From: Mike Josey <mikejosey@btinternet.com>
Sent: 25 August 2020 17:46
To: Amy Myer <Amy.Myer@arun.gov.uk>
Cc: Collins Paul <ppcplanner@btinternet.com>; Cllr. June Hamilton <Cllr.June.Hamilton@arun.gov.uk>
Subject: P/116/19/OUT - Further objection

From: Mike Josey (owner occupier of Sefter Cottage the property immediately adjacent and south of the proposed development)

Planning Application Ref P/116/19/OUT

Visibility Splays of Proposed Site Access

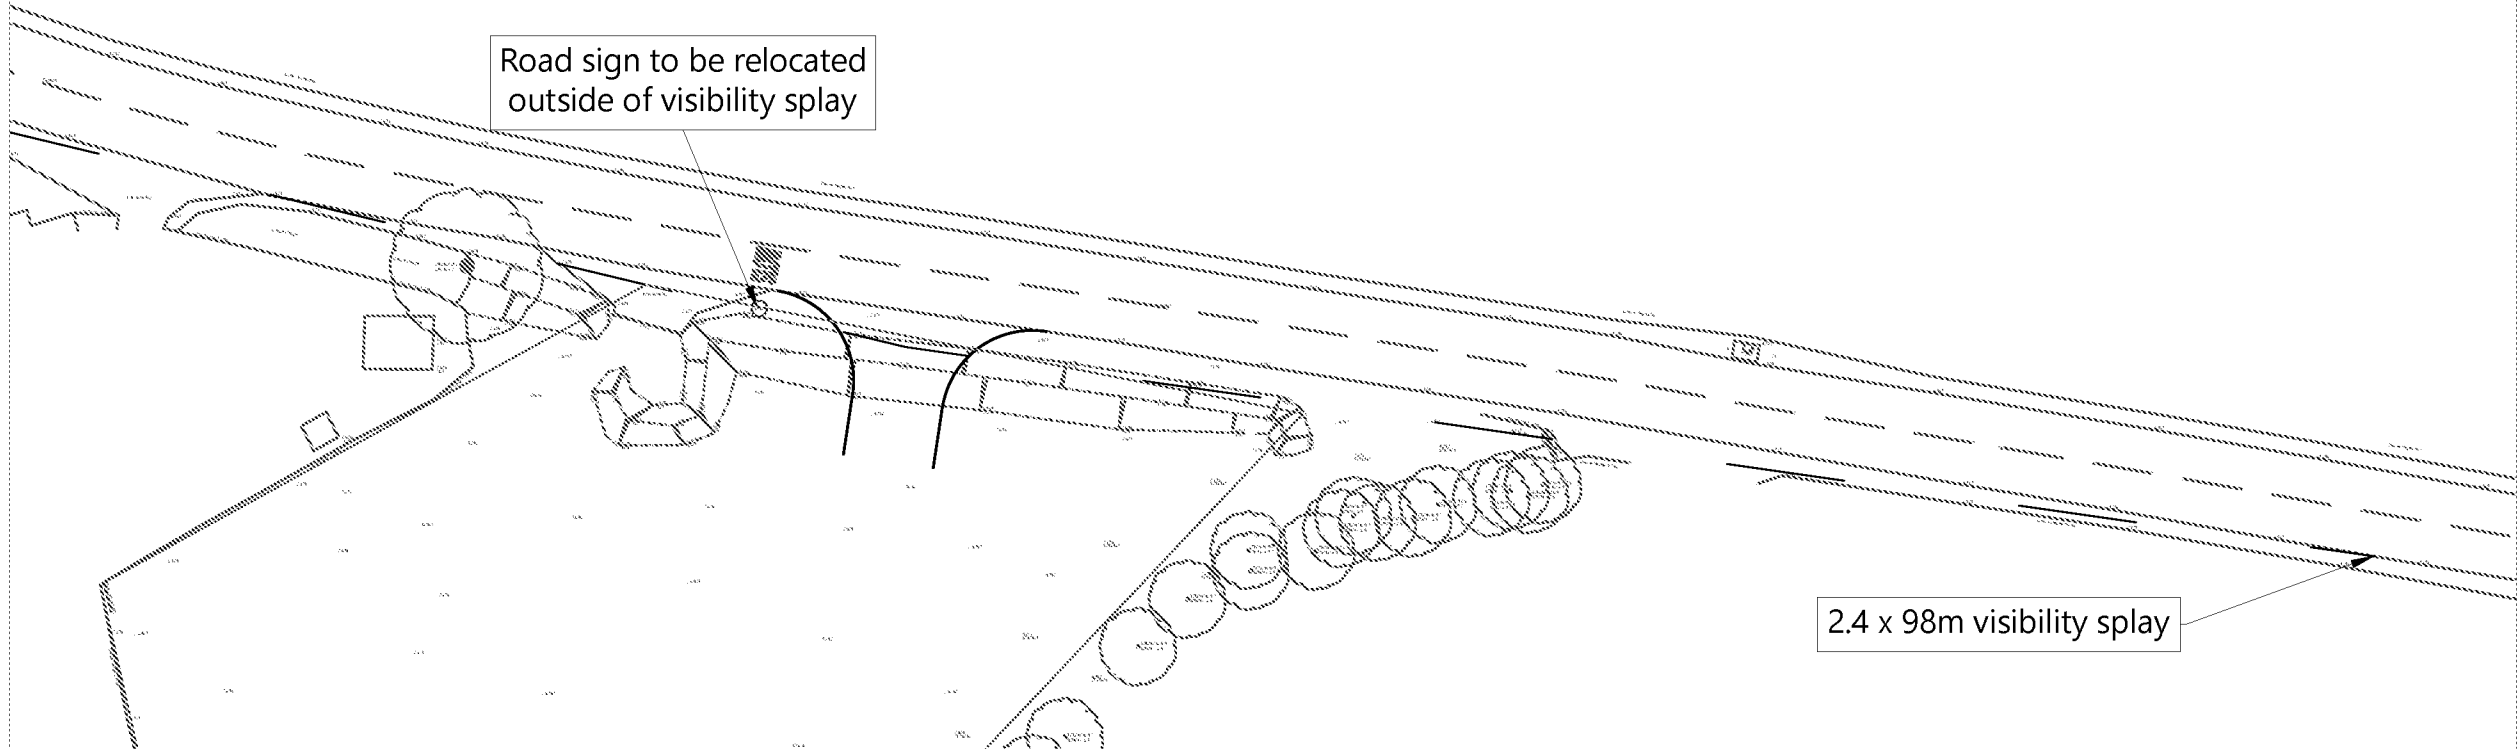
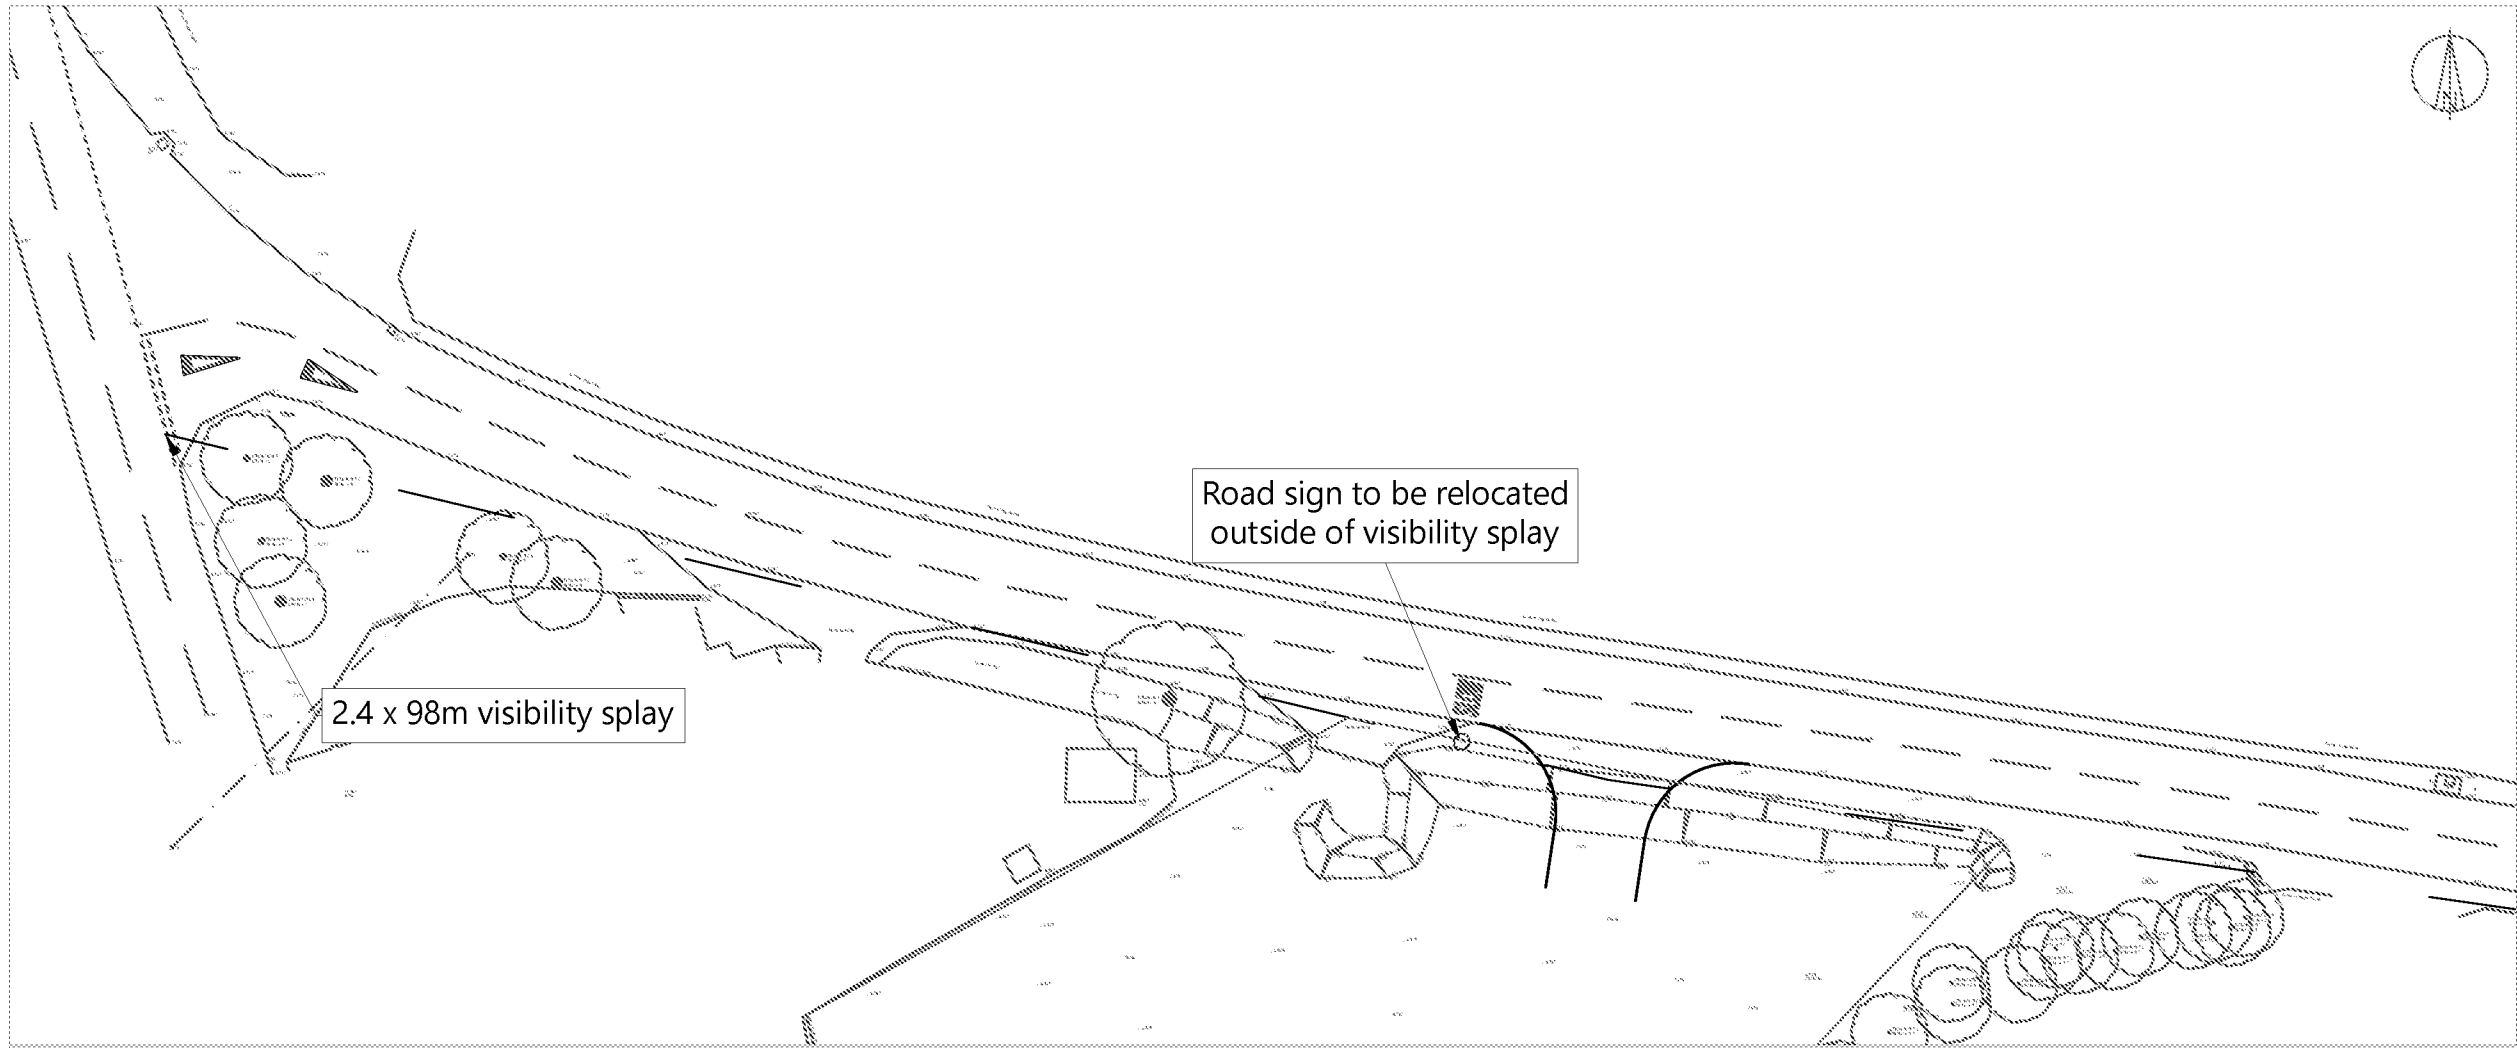
I note also that in their submission of 7 May, the Local Highways Authority stated that the "applicant has not demonstrated maximum achievable visibility splays at either the existing or proposed access points". To date, it appears from the planning correspondence that this issue has not been resolved but as a resident with a clear view of Sefter Road, I can confirm that on most weekday mornings, the proposed entrance to this development is obstructed by queuing traffic waiting to join Pagham Road.
